CITY OF ALBUQUERQUE

February 12, 2020

RE: US Eagle FCU – Juan Tabo
1955 Juan Tabo NE
Grading and Drainage Plan Stamp Date: 11/21/19
Hydrology File: H21D029

Based on the submittal received on 2/7/20, the Grading and Drainage Plan cannot be approved until the following are corrected:

SHEET NUMBER:
C-101

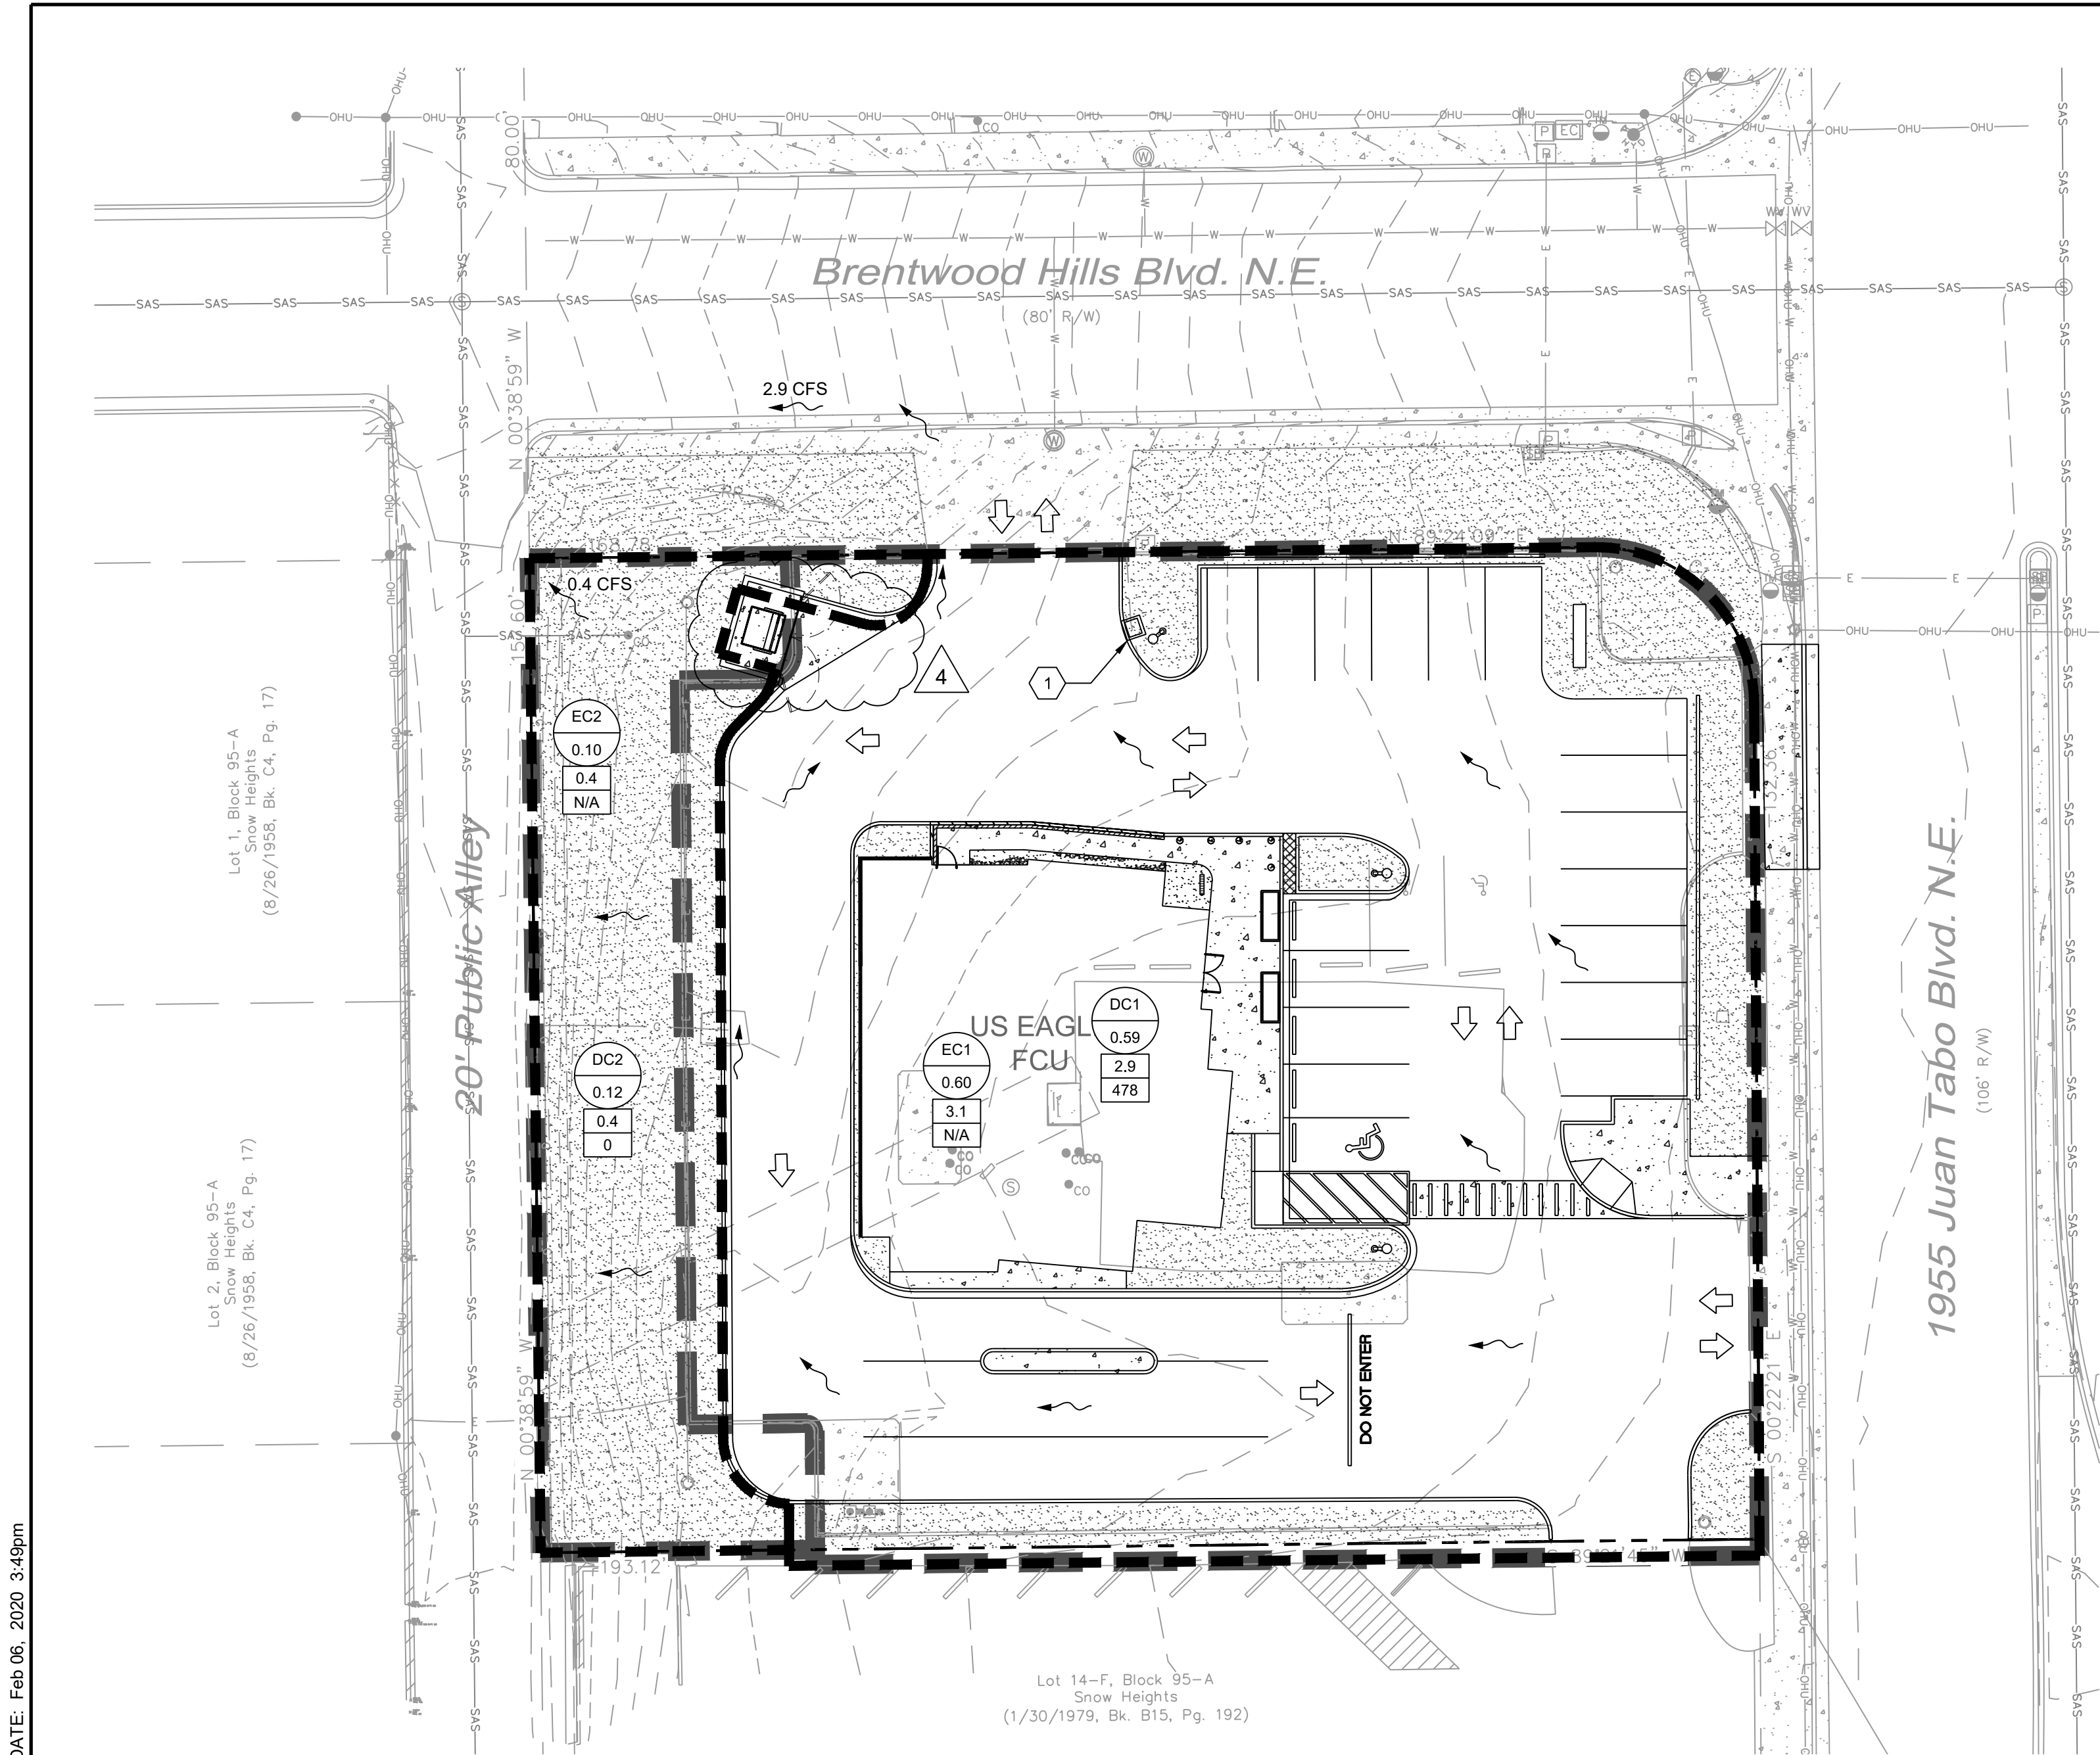
3. Payment in Lieu (Amount = $481\text{CF} \times \$8/\text{CF} = \3848 , per sheet C-101) of onsite management of the SWQV must be made. Take three copies of the treasury deposit slip to the Treasury and then include one copy of the paid deposit slip when resubmitting.

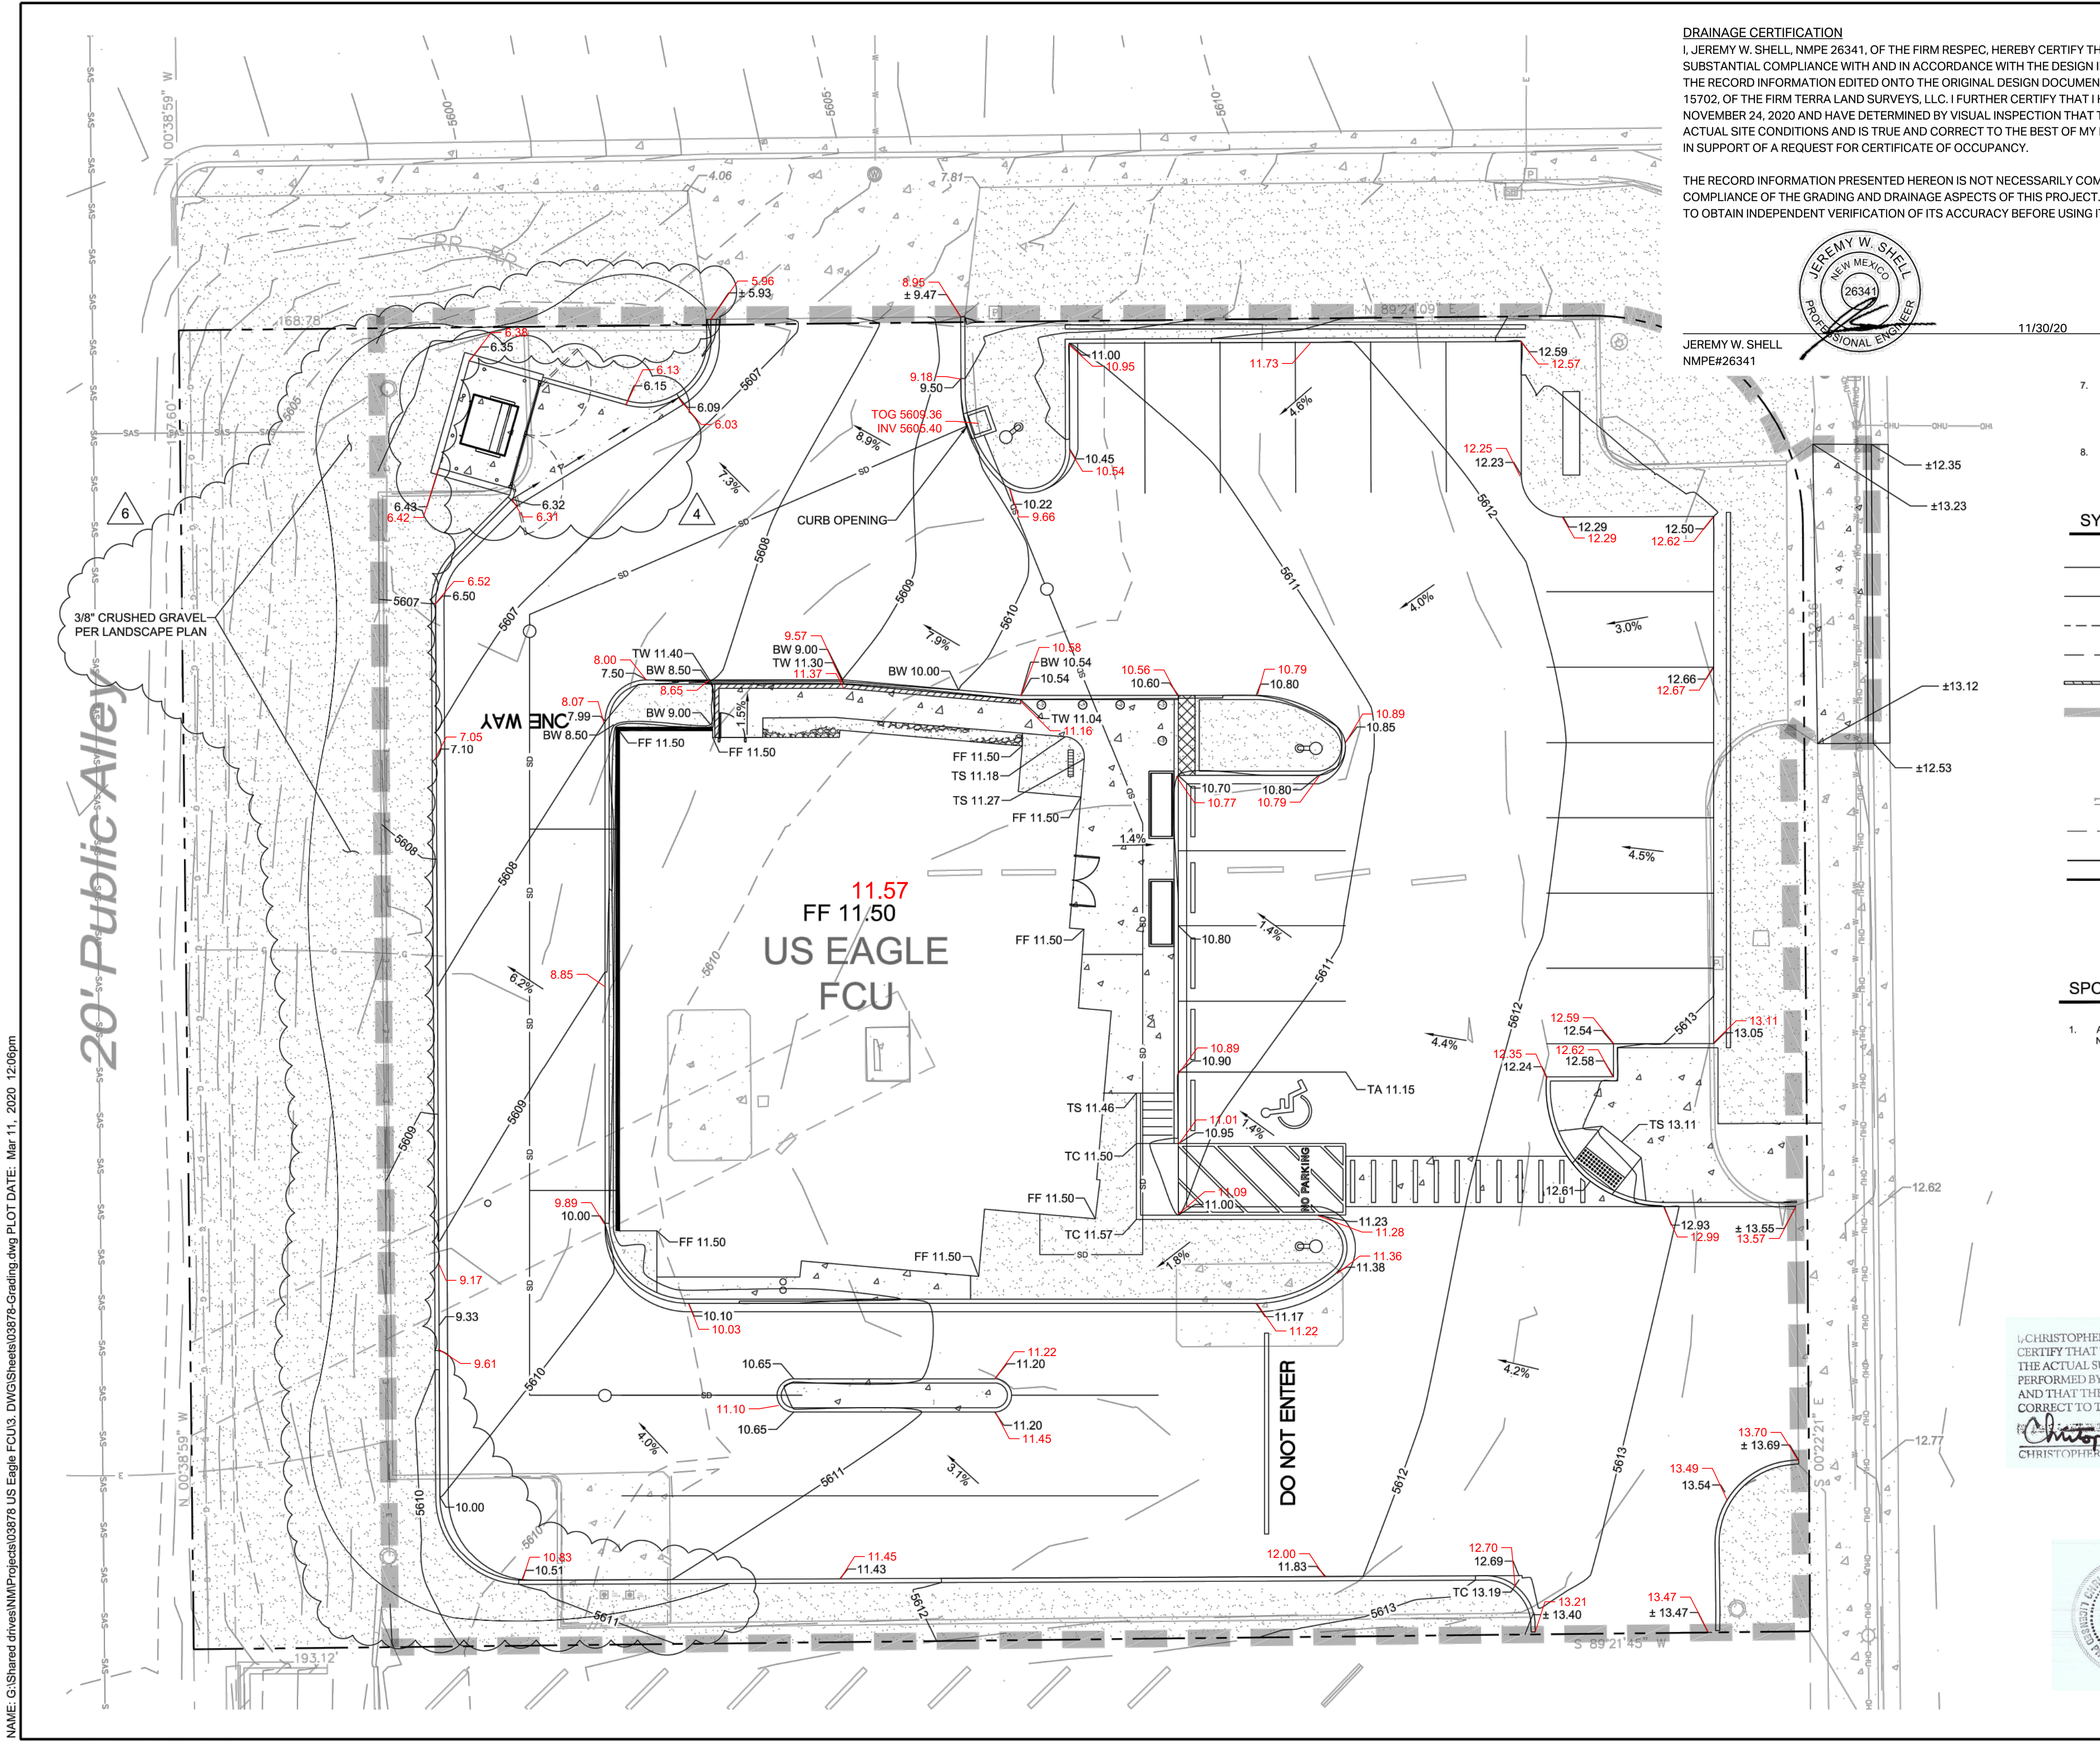
1. The Engineer's Stamp Date needs to be updated with each resubmittal.
2. Show the grading and paving for rebuilding the alley. The alley needs to be reconstructed to current City Standards and convey drainage out to Brentwood Hills. A public Work Order is required.

4. Provide slope stabilization for the sloped area between the alley and parking lot.
5. As a reminder, if the project total area of disturbance (including the staging area and any work within the adjacent Right-of-Way) is 1 acre or more, then an Erosion and Sediment Control (ESC) Plan and Owner's certified Notice of Intent (NOI) is required to be submitted to the Stormwater Quality Engineer (Doug Hughes, PE, jhughes@cabq.gov, 924-3420) 14 days prior to any earth disturbance.
